EXHIBITION OF ENVIRONMENTAL ASSESSMENT FOR NUNDAH BANK THIRD TRACK (MP 10_0094)

NUNDAH BANK THIRD TRACK PROJECT (MP 10 0094) - OEH COMMENTS ON EXHIBITED EA

Vegetation Communities and Hollow Bearing Trees Figure 7.2B

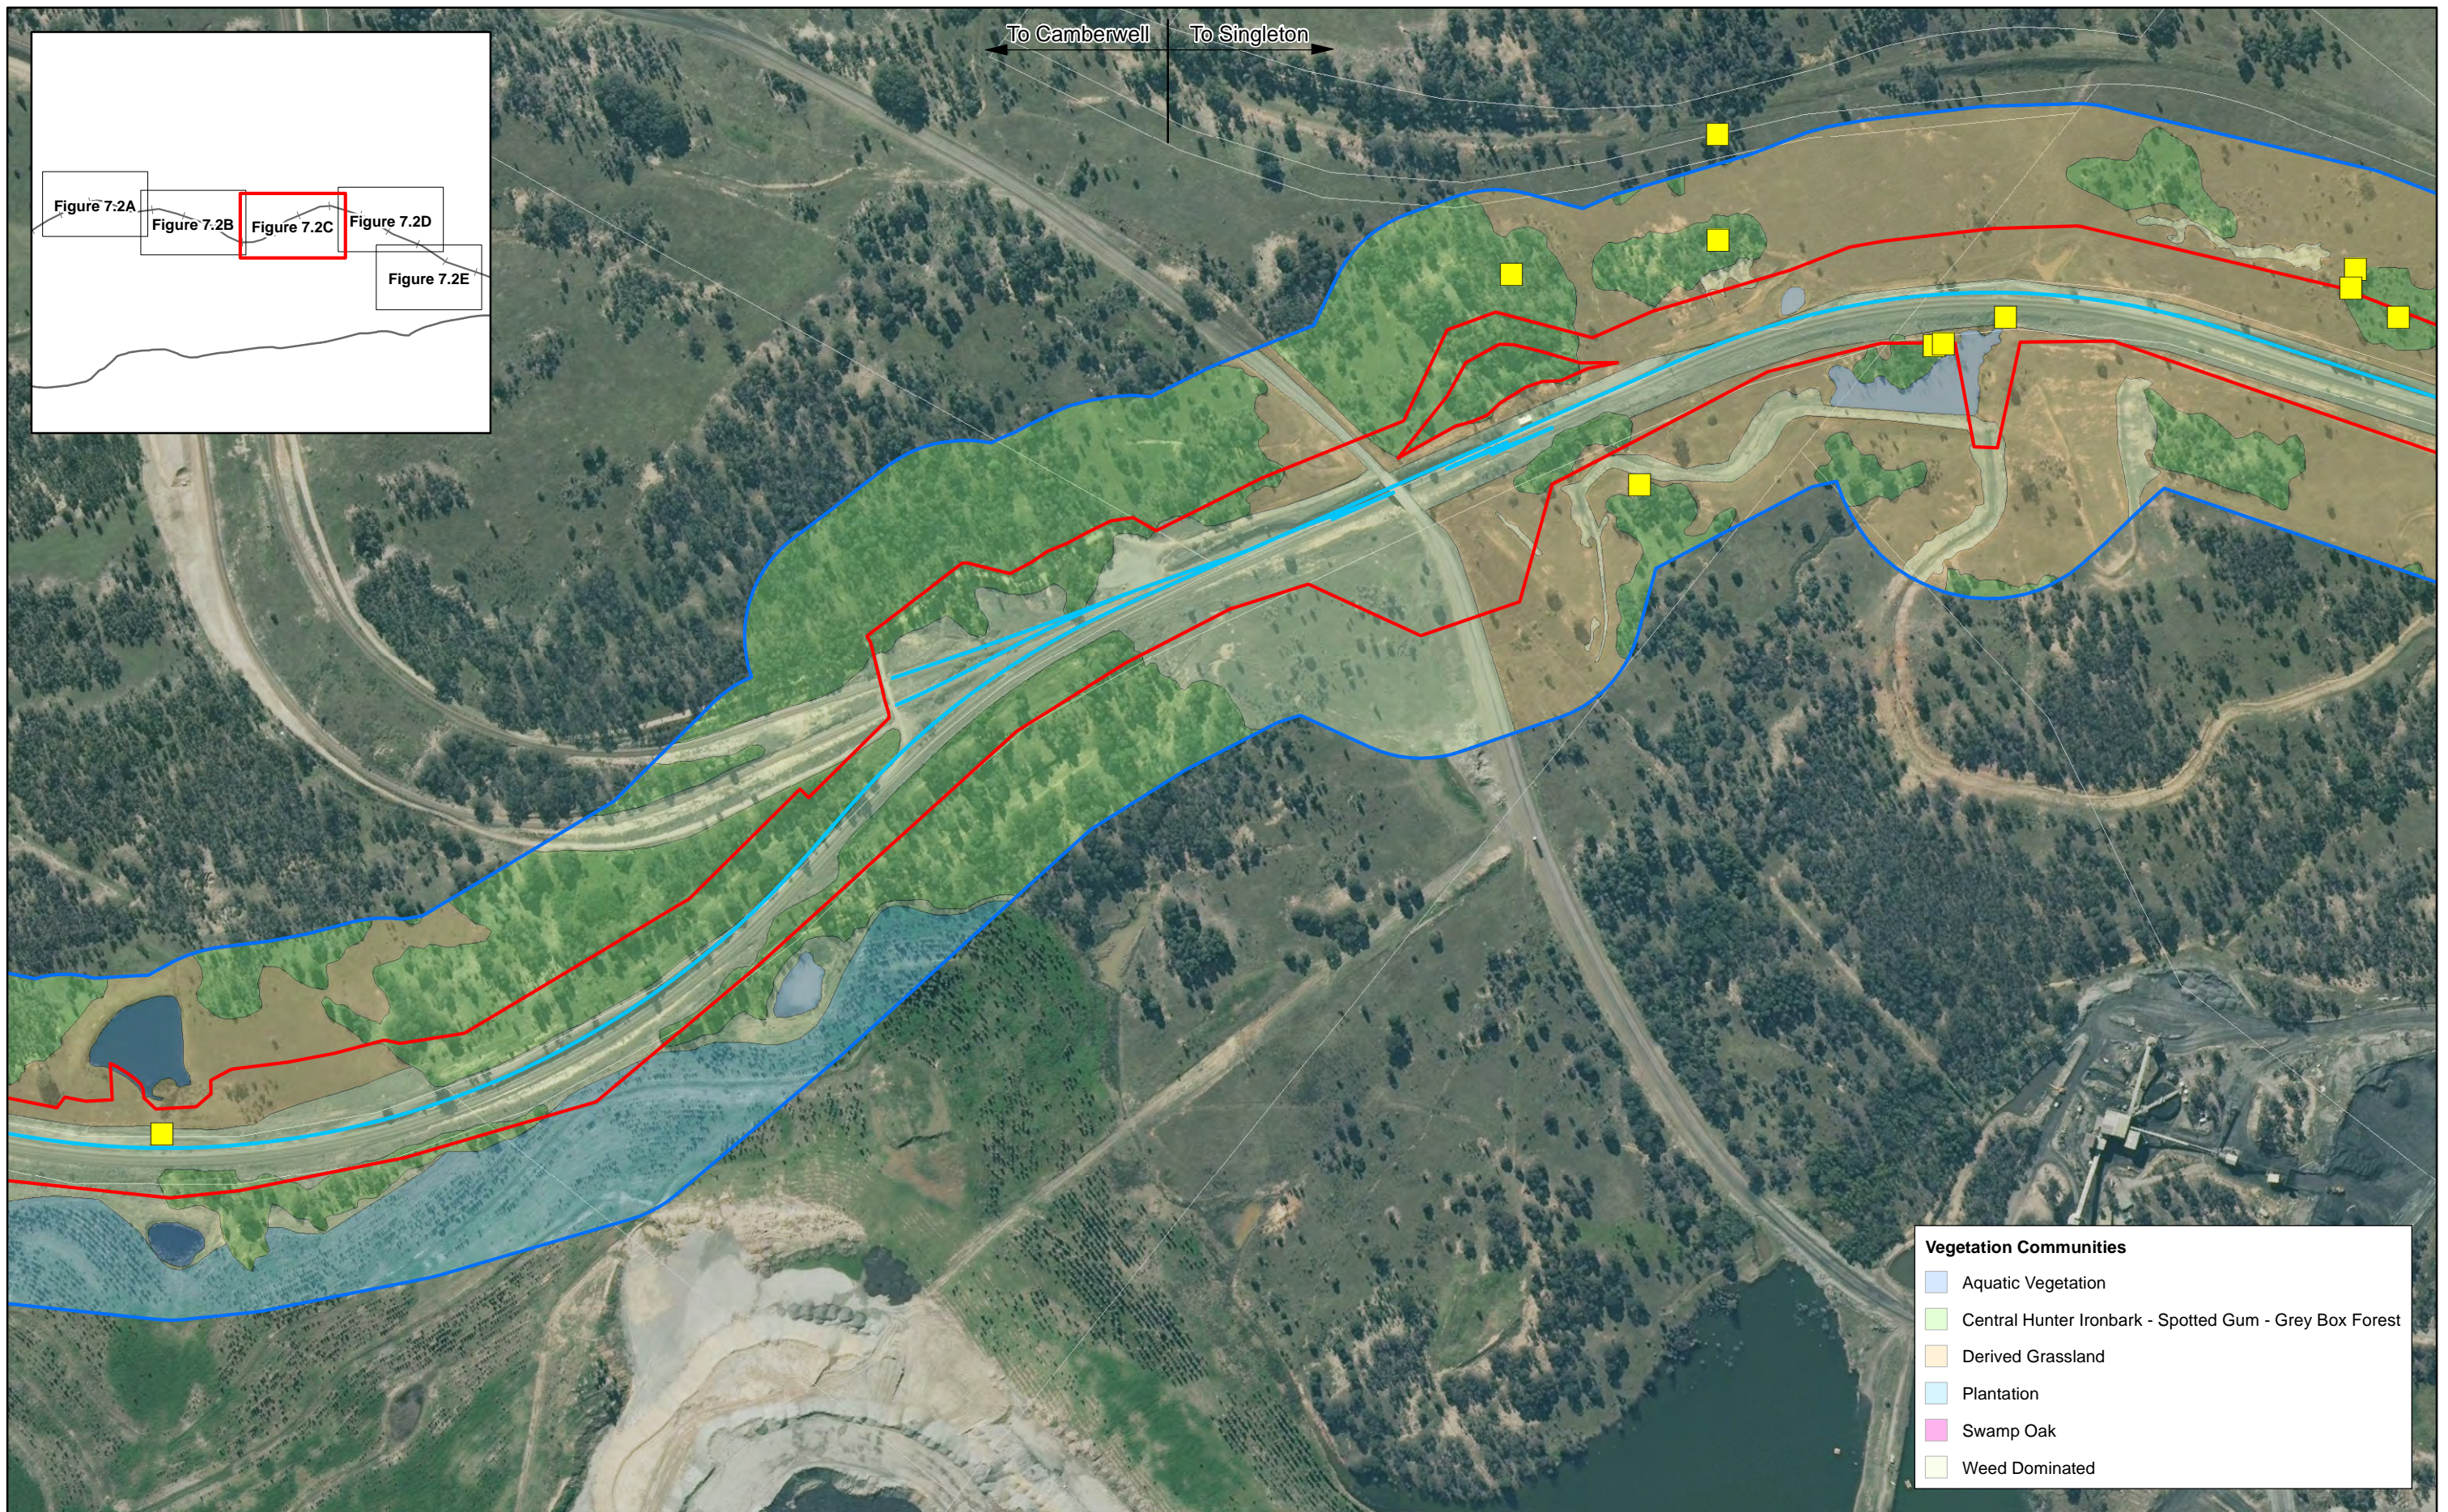
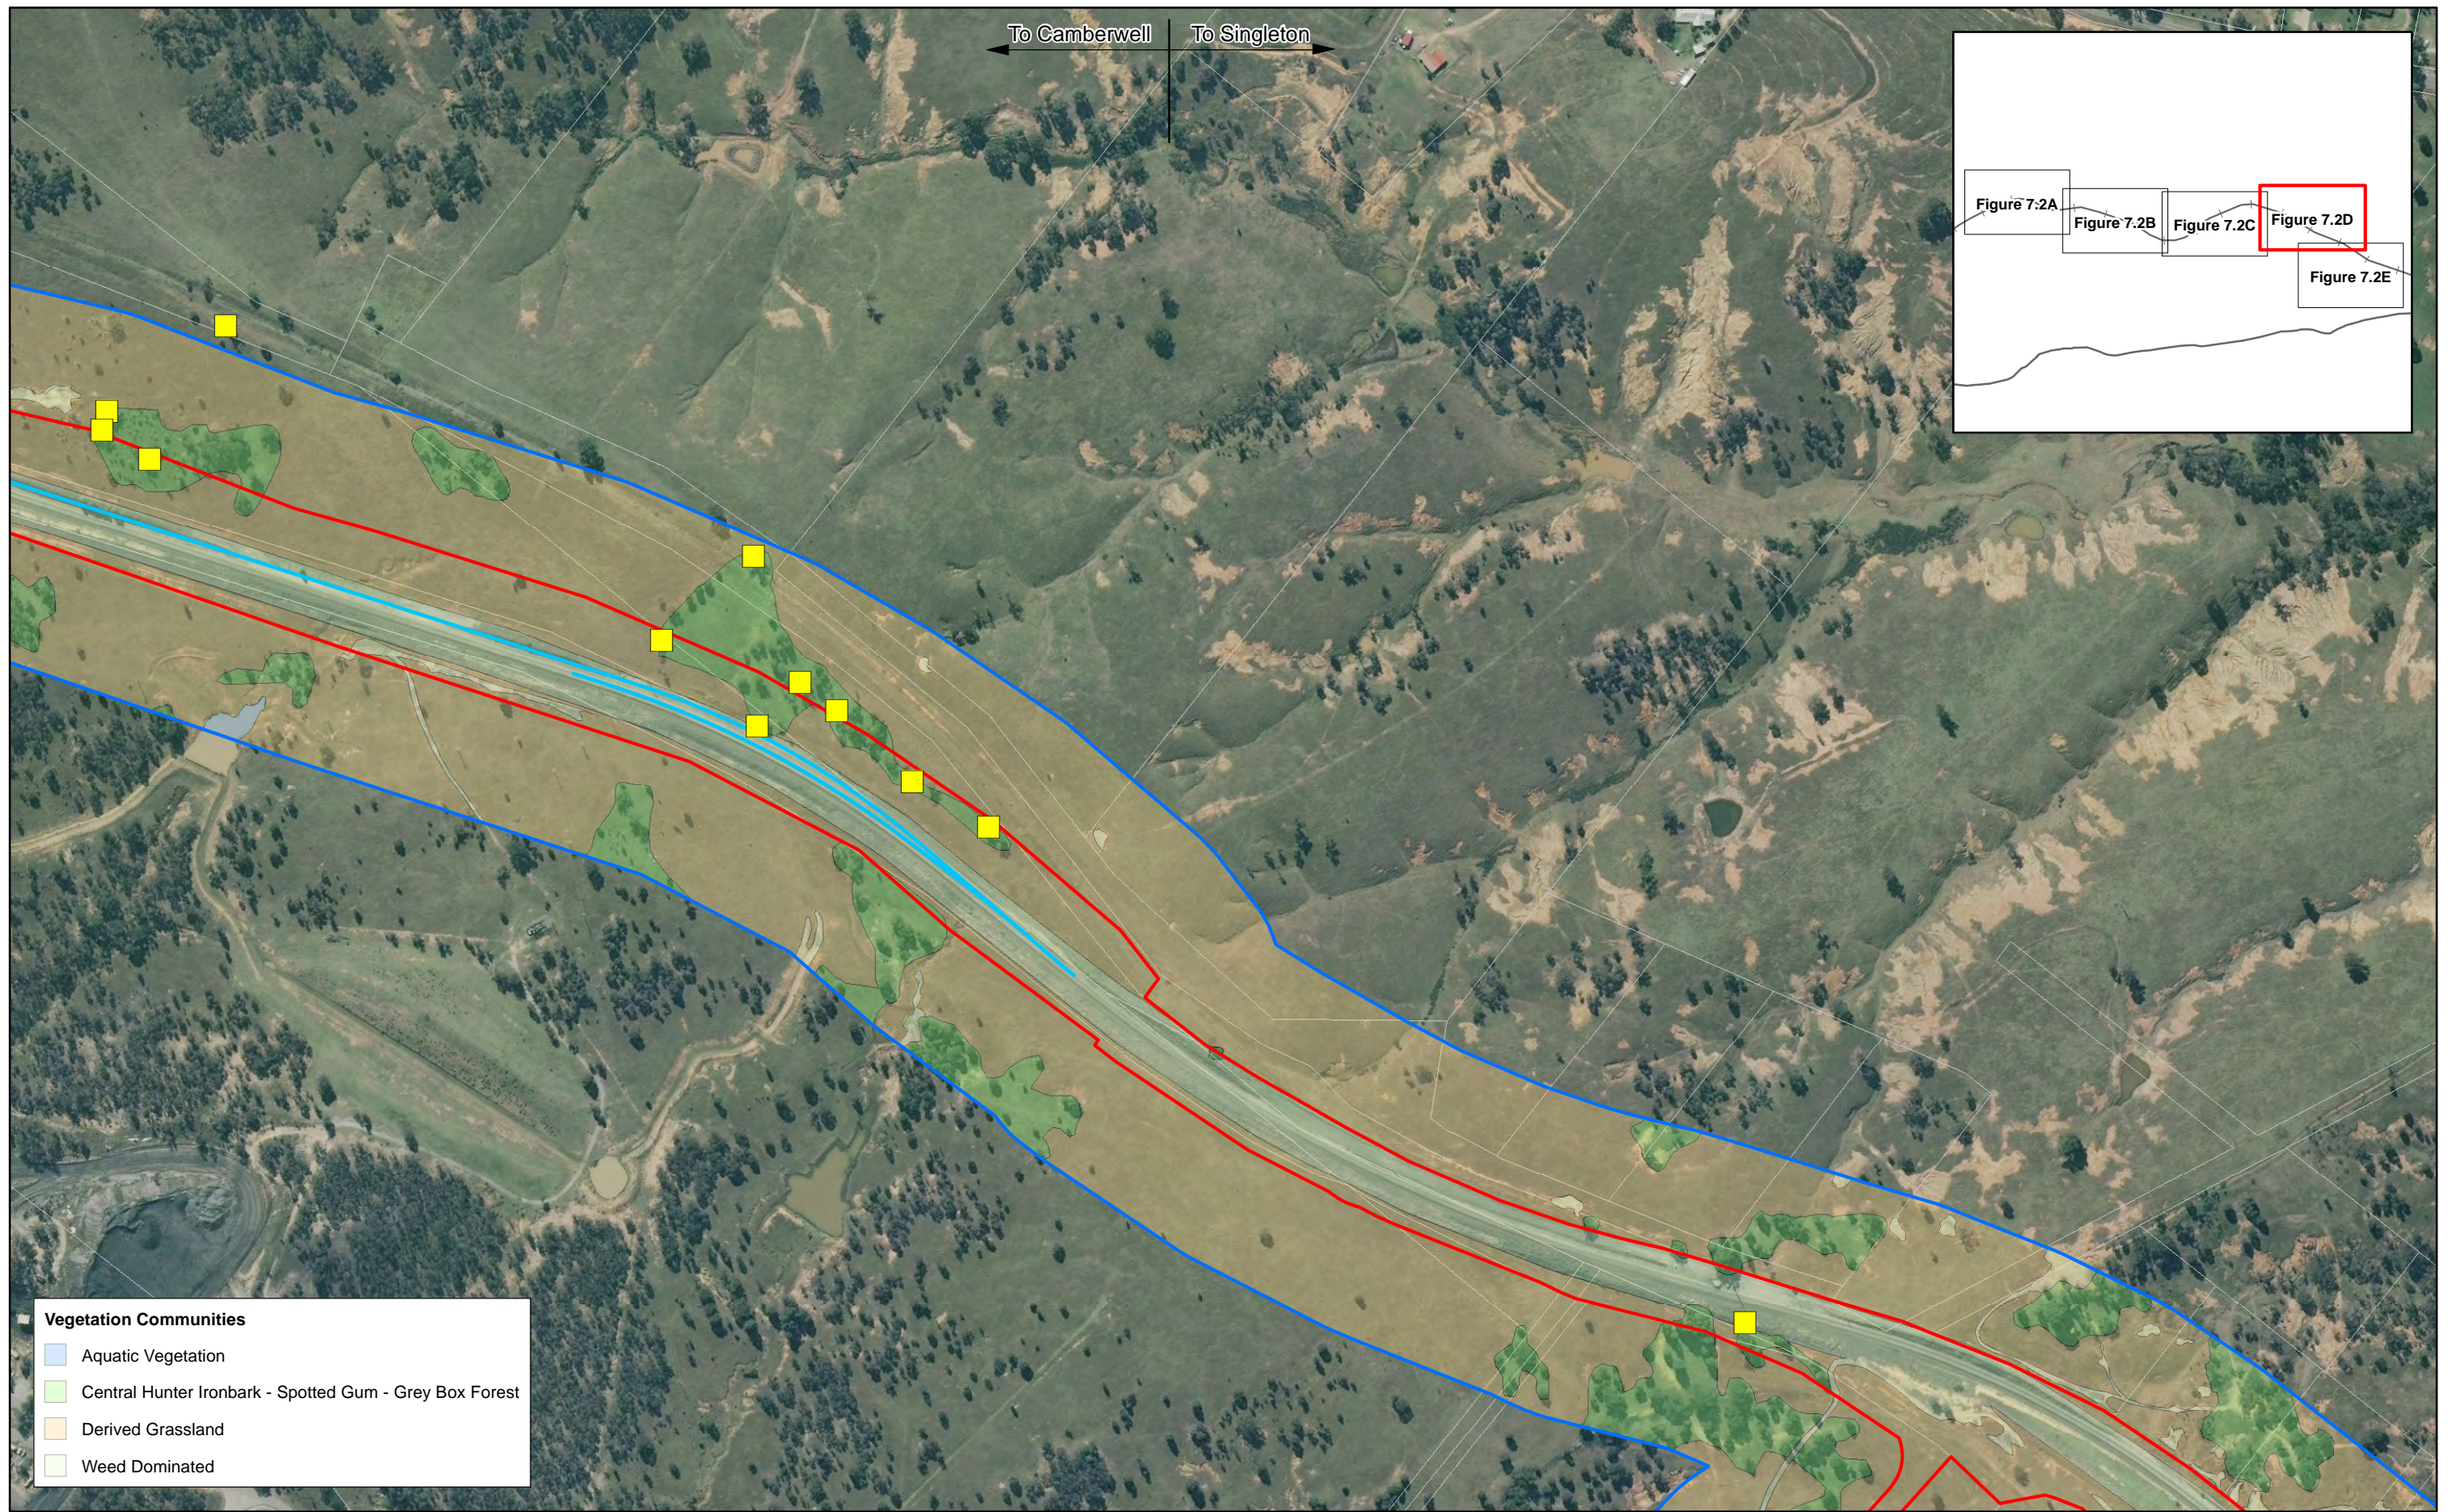
Section 5.2 (pg. 49) of the Ecology report, has a reference to an area of Swamp Oak Forest (0.12 ha) affected by the proposal which appears to occur near the northern limit of the project area (Figure 3A). However, this vegetation community is not described in section 3.2 of the Ecology report nor does its conservation significance appear to have been evaluated. OEH considers this may represent 'Swamp Oak floodplain forest of the NSW North Coast, Sydney Basin and South East Corner Bioregions' endangered ecological community (EEC). OEH notes that in Table 4.1 this EEC was not considered to occur in the study area. In the absence of details about the 'Swamp Oak' mapped on site it is not clear to OEH whether or not this vegetation type matches the EEC criteria in the final determination (NSW Scientific Committee 2004). As such OEH recommends that the proponent provide further details of the Swamp Oak Forest on site (particularly floristic composition, vegetation structure, an indication of the frequency and

duration of waterlogging at the site, and an indication of the salinity of the groundwater), and if any of the 0.12 ha to be affected by the proposal is EEC vegetation, and if so must be offset.
